Infrastructure Planning Directorate  
Planning Inspectorate  
Temple Quay House  
Temple Quay  
Bristol  
BS1 6PN

**Our ref:** RA/2015/132060/04-L01  
**Your ref:** EN60004  
**Our ID:** 10031562  
**Date:** 2 November 2015

### DEADLINE 3 SUBMISSIONS & NOTIFICATIONS

**A REPLACEMENT HIGH-PRESSURE GAS PIPELINE WITHIN A BORED TUNNEL BENEATH THE HUMBER ESTUARY AND ASSOCIATED DEVELOPMENT, INCLUDING A CONNECTING PIPELINE, MINOR MODIFICATIONS TO PAULL ABOVE GROUND INSTALLATION AND ASSOCIATED TEMPORARY LAY DOWN, WORKING AND MITIGATION AREAS. FROM PAULL, EAST RIDING OF YORKSHIRE TO GOXHILL, NORTH LINCOLNSHIRE.**

RIVER HUMBER GAS PIPELINE REPLACEMENT PROJECT		
INDICATIVE PAULL SITE LAYOUT FIGURE 2.4 B		
REFERENCE		
DRAWN	CHECKED	APPROVED
JN	KB	NH
SCALE	ORIG SIZE	SHEET
1 : 1000	A1	1 of 1
DATE		REVISION
12 OCT 15		03

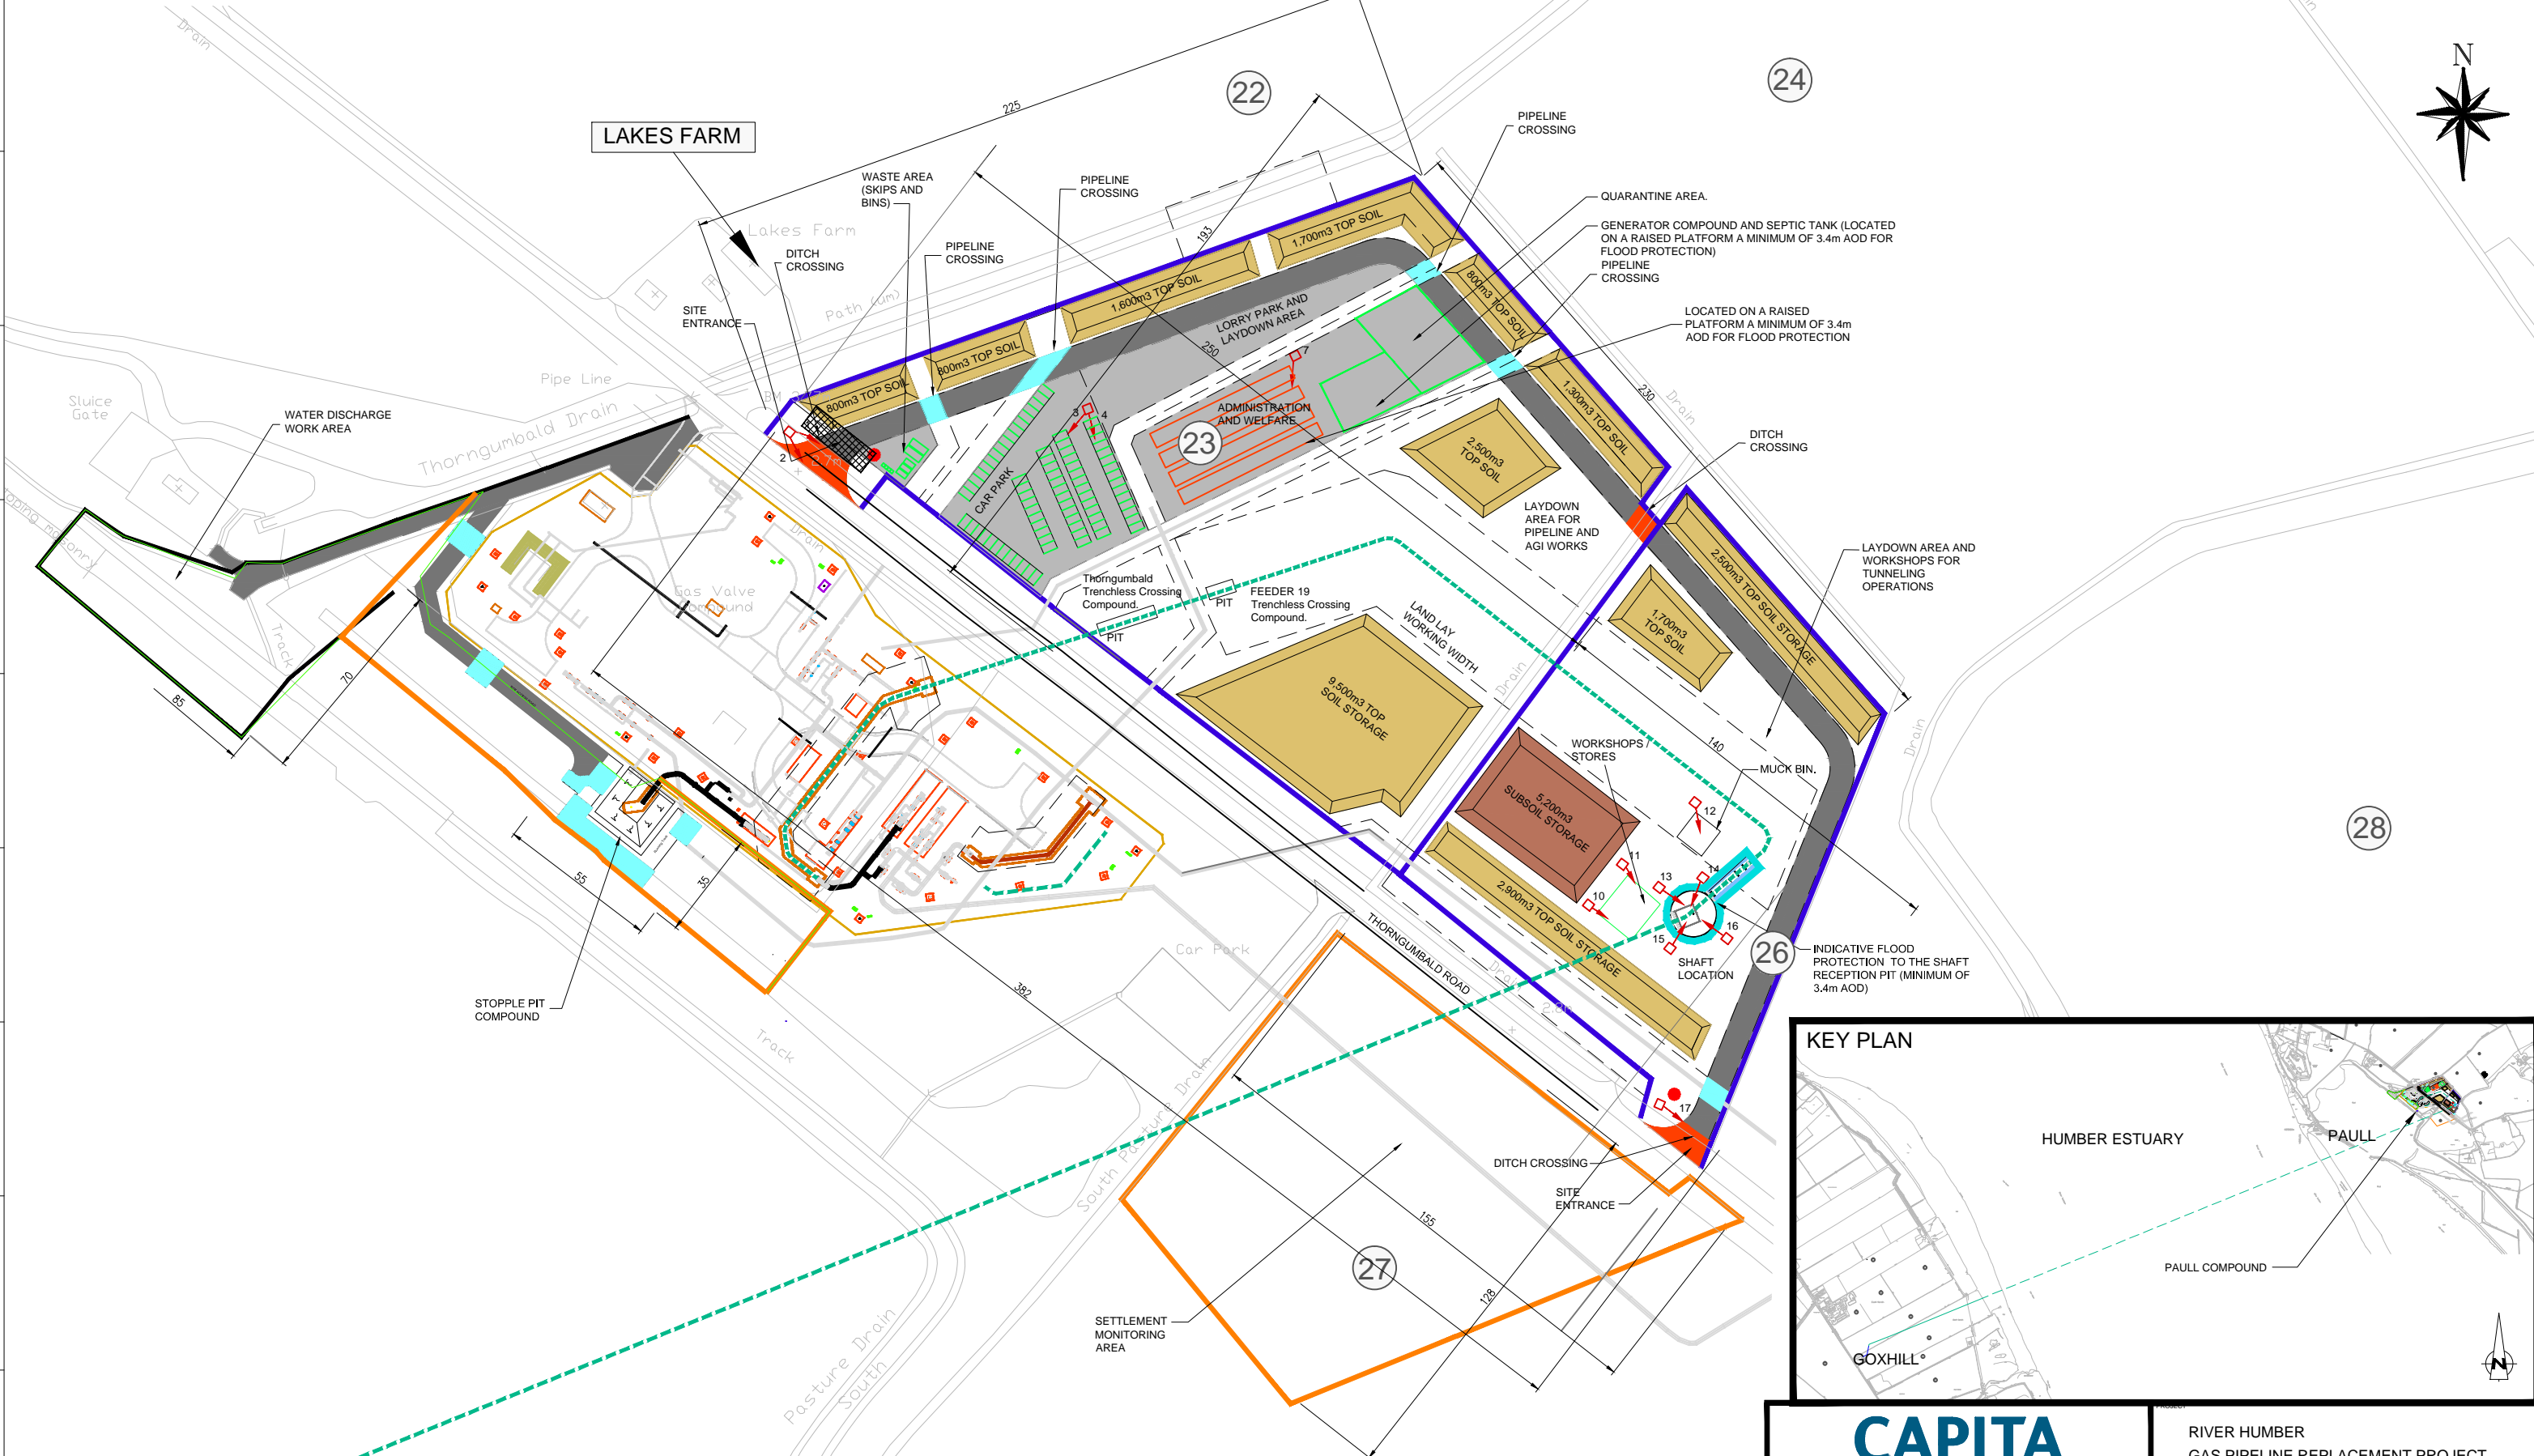
2. Flood Bund clarification - The Site Layout Plans (DCO Document Reference 2.4) still appear not to show a continuous flood bund surrounding the drive pit. There are top soil storage areas, but these don't appear to be continuous. However, the formally submitted documentation clearly states that a continuous flood bund to a height of 3.4mAODN will be provided around the drive pit. As such, a suitable requirement must be included to secure this measure. The requirement should specify a minimum height of 3.4mAODN, rather than the 1.4m (above ground level) mentioned in some of the documents. It is essential that the heights in metres quoted in paragraphs 3.1.10 and 3.1.13 are stated in metres AOD, otherwise they indicate ambiguous relative height increases instead of heights calibrated to Ordnance Datum. In addition, the heights in metres cited in section 3.1.13 for Paull, should match those in Table 3.5 - currently they do not.
